**Harnett County**  
420 McKinney Pkwy  
LILLINGTON, NC 27546  
Phone:  
Fax:

10/27/2025

**SUBJECT: SFD2501-0087**  
**SINGLE FAMILY DWELLING**

Here are the results of all Inspections located at **4727 NC 55 E:**

FOUNDATION PLAN
1/4" = 1'-0"

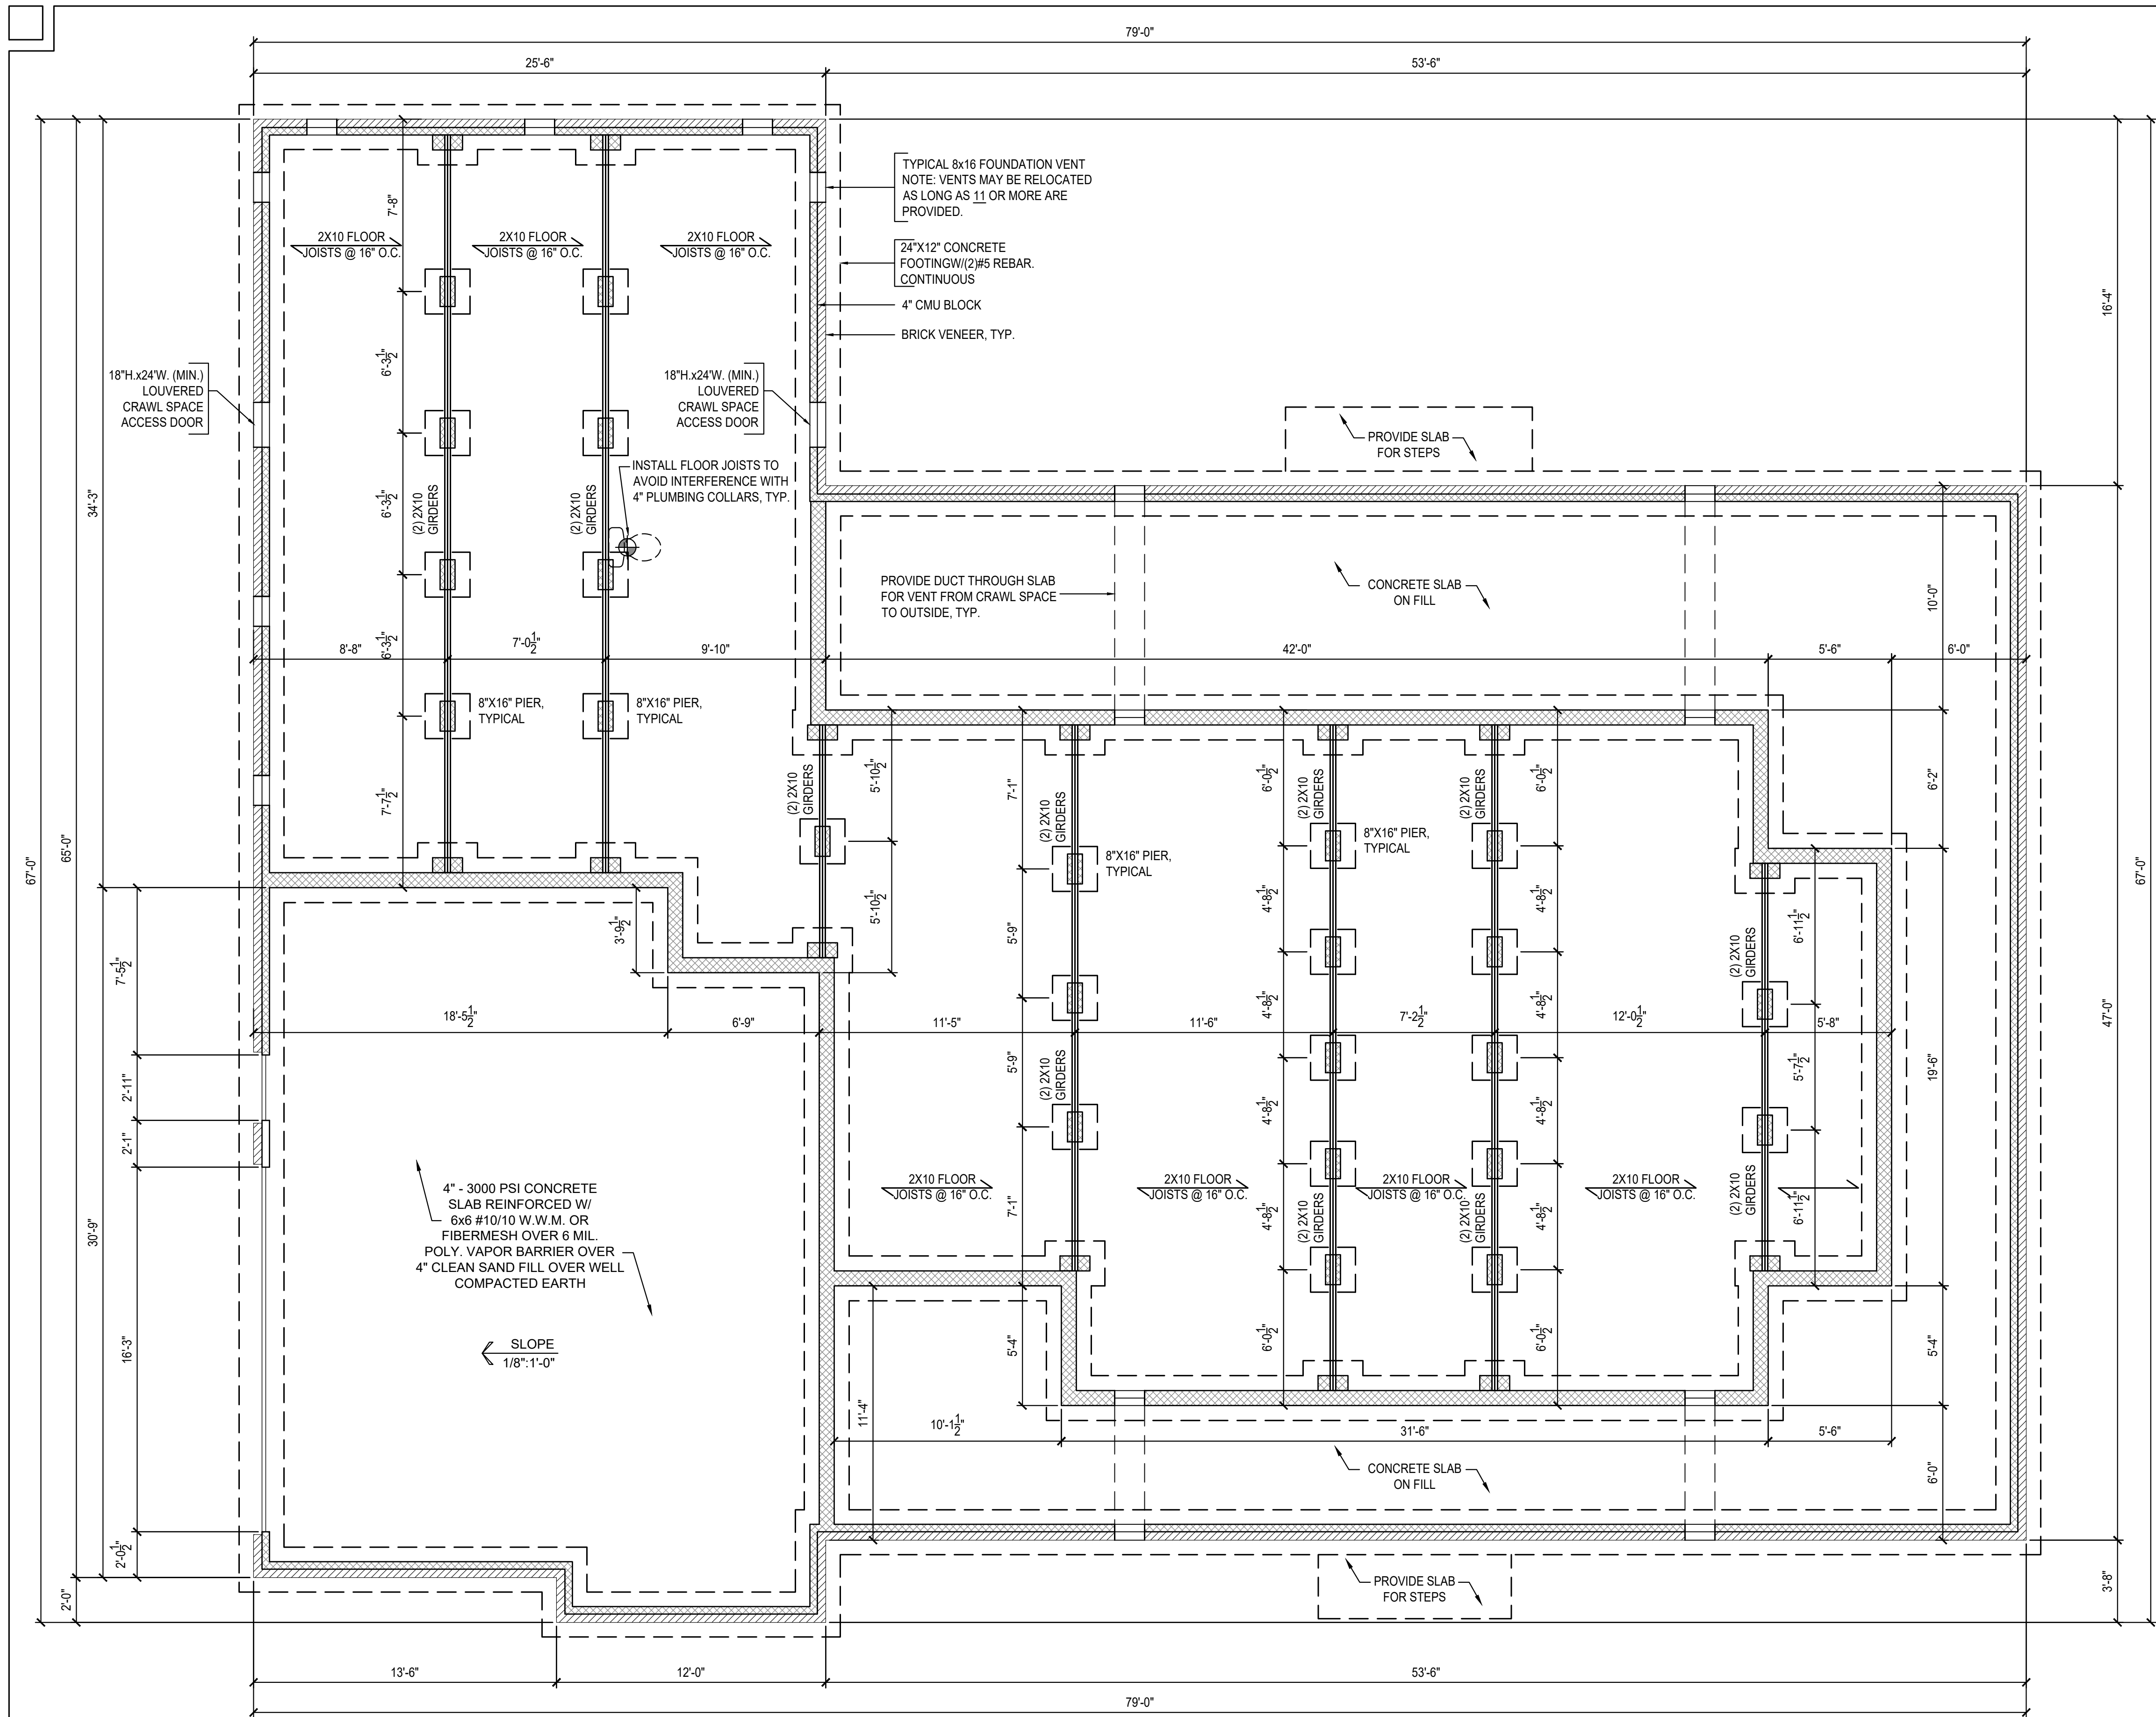
Inspection Type: OPEN FLOOR  
Scheduled Date/Time: 3/31/2025  
Completed Date/Time: 3/31/2025  
Inspector: Steven Gazlay  
Result: DISAPPROVED  
Remarks:  
Notes: Girders must fully bear on piers. Need 1/2 standoff from girders to masonry or flashing. Ensure joists are doubled where required.

Inspection Type: OPEN FLOOR  
Scheduled Date/Time: 4/1/2025  
Completed Date/Time: 4/1/2025  
Inspector: Steven Gazlay  
Result: APPROVED W/EXC  
Remarks:  
Notes: Ensure joists are double where required (under stairs, island, and any bearing partitions).

Job	Truss	Truss Type	Qty	Ply	
B1124-6094	A2	Hip Girder	1	2	Job Reference (optional)

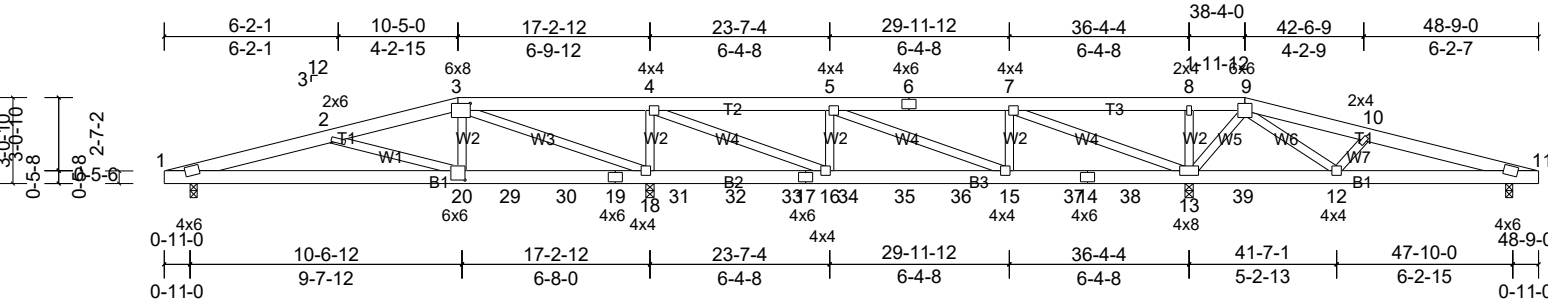
1. Missing roof boots.2. Missing 2 inch washers on garage wing wall. 3. Missing portal frame strapping.4. Chase around Plumbing in.5. Need hangers or properly installed ledger strip on stairwell platform joists.6. Pot filler requires a cut off. 7. Missing insulation stops along garage.8. Drywall window installed in incorrect location.9. Rear slider not installed.10. Fire block top of fireplace chase.11. Repair holes in air barriers throughout. 12. Nail multiply trusses per MFG. 13. Need correct nails in trust hangers.14. Strap Gables for uplift where required.15. Missing bracing and standard gable brace on B1GE.16. Missing 2 x 4 blocking at Ridge on first two bays at gable trusses17. Missing support under post at foyer, need to transfer load all the way to dirt.18. Provide engineering on size and span span of angle that is supporting corrugated decking.19. Gas test down.20. Missing hurricane clips on A2 truss.21. Do not insulate.

Job	Truss	Truss Type	Qty	Ply	
B1124-6094	B1-GE	Piggyback Base Structural Gable	1	1	Job Reference (optional)

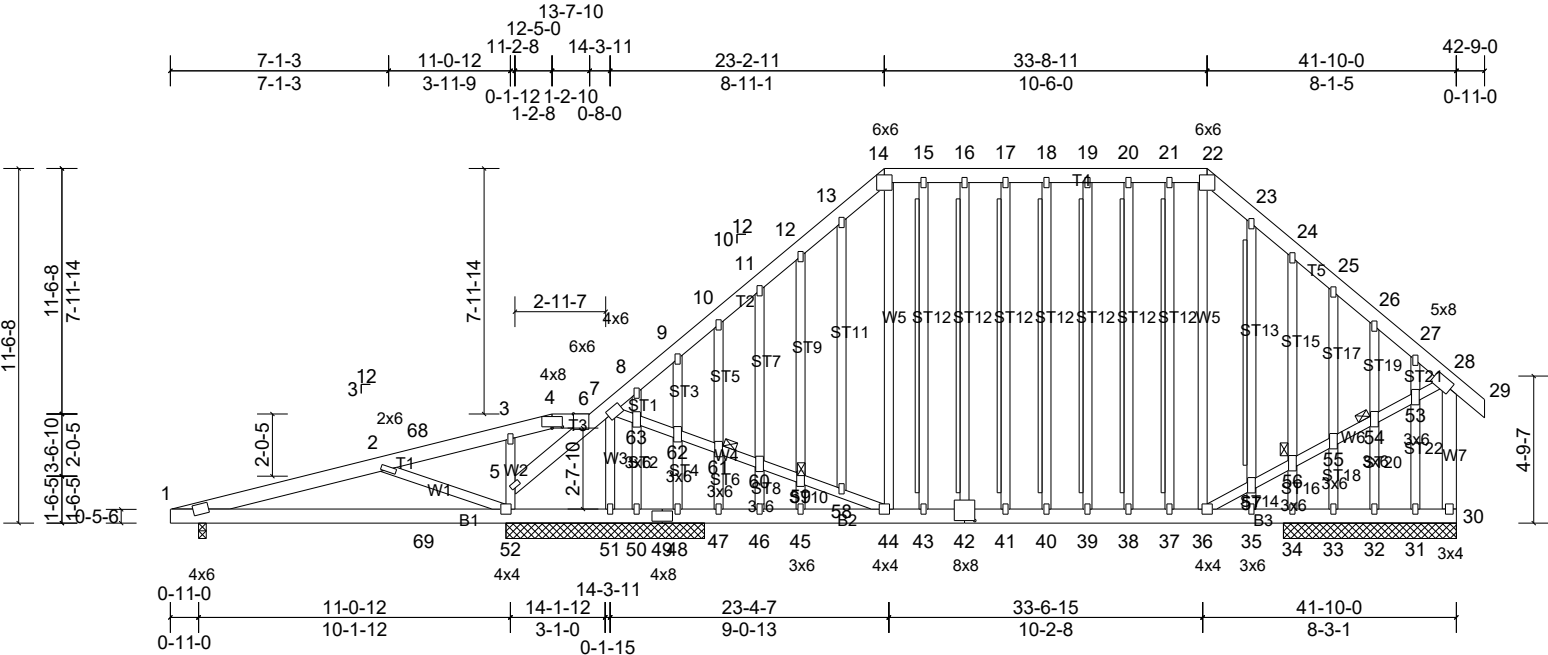
Still need to inspection letter for angle iron used to support porch decking. Verify standard gable brace on BGE1.
